The Lodge
1 Armstrong Road
Littlemore
Oxford OX4 4XT

Application No.: 21/03267/OUT

Proposal: Outline planning permission (all matters reserved except for access) for the erection of buildings comprising logistics (Use Class B8) and ancillary Office (Use Class E(g)(i)) floorspace and associated infrastructure; construction of new site access from the B4100; creation of internal roads and access routes; and hard and soft landscaping

Location: OS Parcel 0006 South East Of Baynards House Adjoining A43, Baynards Green

Drawing Title: **PARAMETER PLAN 08
VEGETATION RETENTION
& REMOVAL**

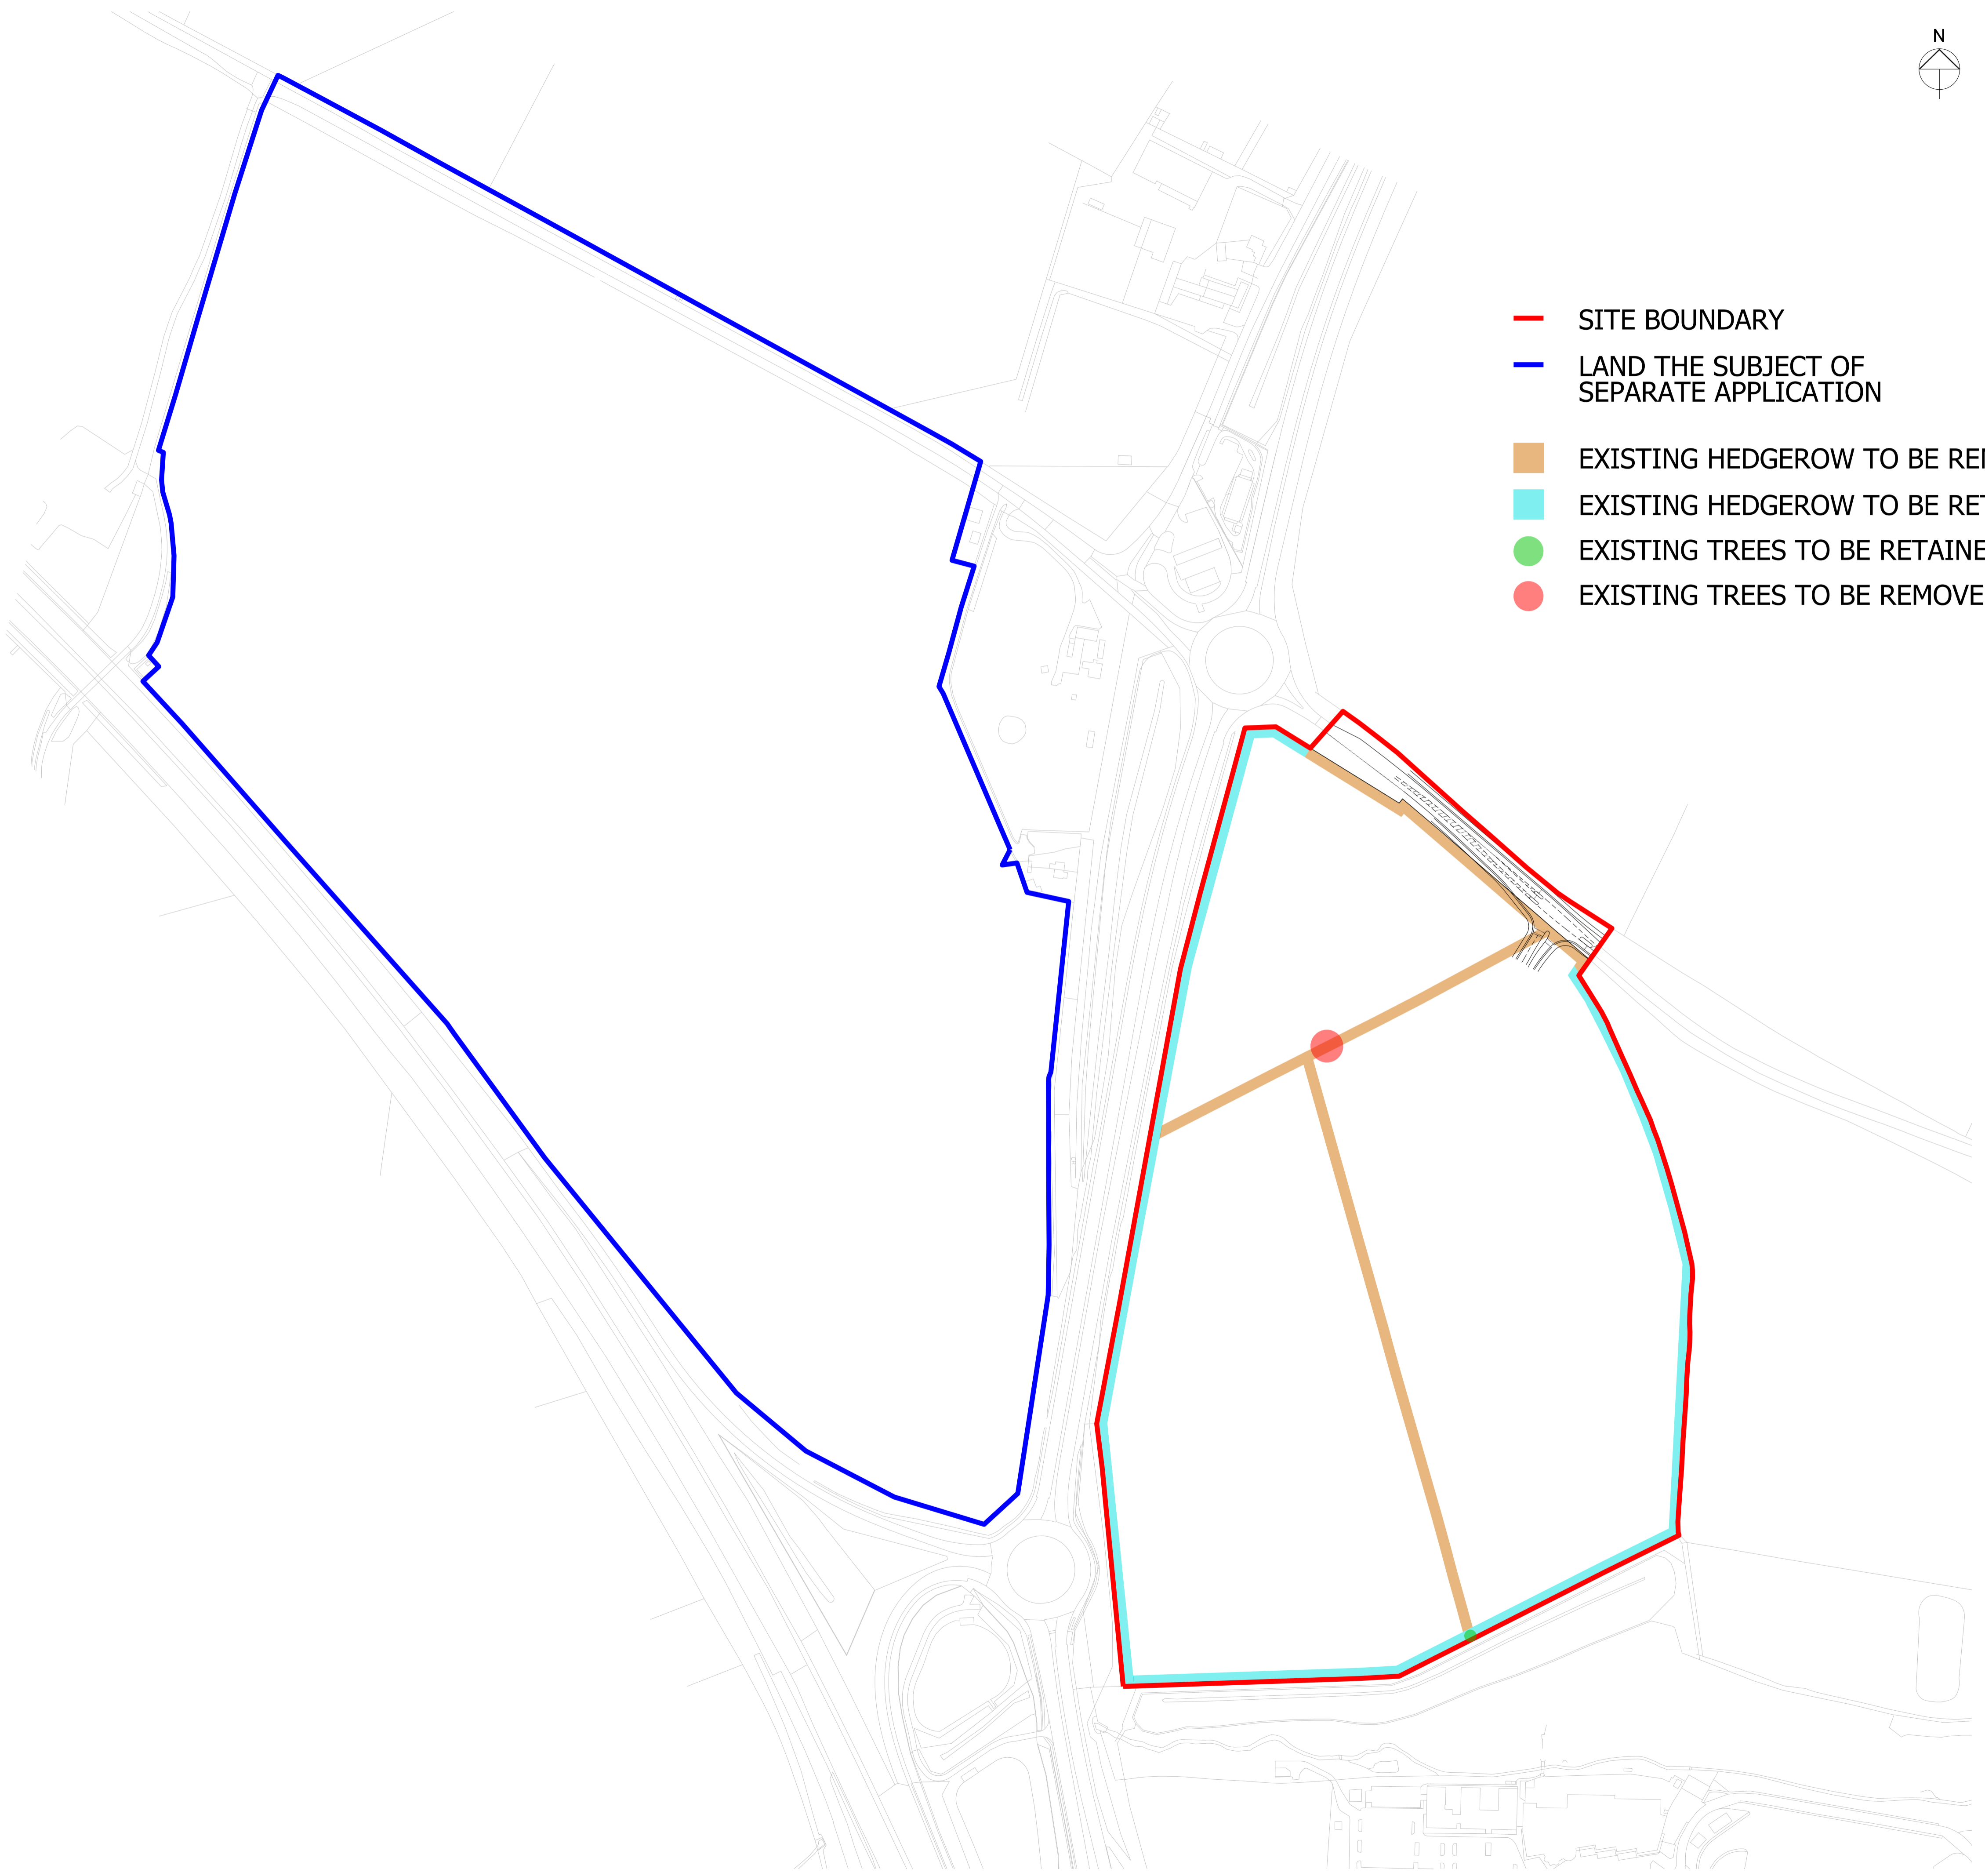
As stated in our previous response we are greatly concerned by the loss of hedgerow priority habitat that this development would lead to. We note that the applicant will retain some of the hedgerow and replace some of it onsite. In addition, hedgerow is to be created off site at Piddington resulting in a net gain in hedgerow habitat.

It is very important that hedgerows both on and off site are carefully managed in order to achieve the necessary biodiversity net gain. In general, a rotational cutting regime on a three-year cycle wherever possible (or a two-year cycle where particular reasons justify it) will be of most value to biodiversity. This is for many reasons including allowing the formation of fruit which is a vital winter food source for birds, and allowing butterfly and other invertebrate eggs laid on branches to overwinter. This is an important issue as annual cutting would have a severely detrimental impact on the biodiversity value of the hedgerows. Rare black and brown hairstreak butterflies are very important in the local area and should be considered in the management of the hedgerows. Newly planted hedgerows should include a significant component of blackthorn, the food plant of both black and brown hairstreaks. Retained hedgerows should be protected by a buffer zone of minimum 10m either side of the hedgerow. Buffers should be primarily diverse grassland areas alongside the hedgerows so that they are suitable for invertebrates. There should be no built environment and minimal lighting within the buffer zone.

It is essential that the hedgerows are retained and managed to a very high standard in perpetuity in order to compensate for the permanent loss of hedgerow habitat onsite (see point 3 below).
